November 28, 2016
Code Enforcement Officer
389 Congress St
Portland, ME 04101

Re: 25 Sandy Terrace, Portland, ME
Bearing Wall Removal

Proposed Beam

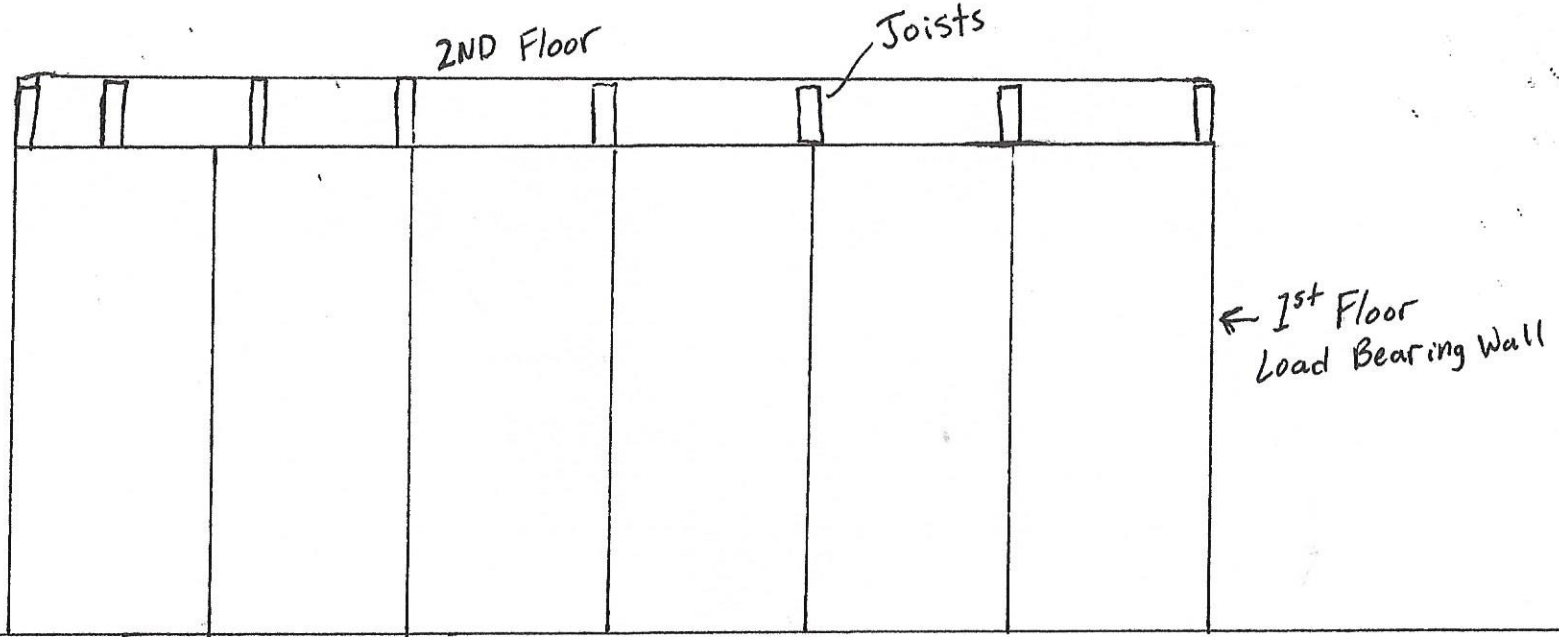
I have visited the above referenced property and observed the existing conditions at the first floor area where a portion of the existing center bearing wall is planned to be removed. The new clear opening will be 13'-6" +/- and the required beam size is a triple 1.75"X9.5" LVL by Boise, with the following properties:

Multiple laminations to be connected with a minimum 2 rows of 16d box/sinker nails at 12" o.c.

Supporting end posts should be minimum 4-2x4's built-up post with Simpson ACE post caps. The new post at the exterior wall will be supported by the foundation wall. The new post adjacent to the stairwell will be supported by an existing concrete filled lally column at the basement. Refer to the attached sketch (by others) for additional information.
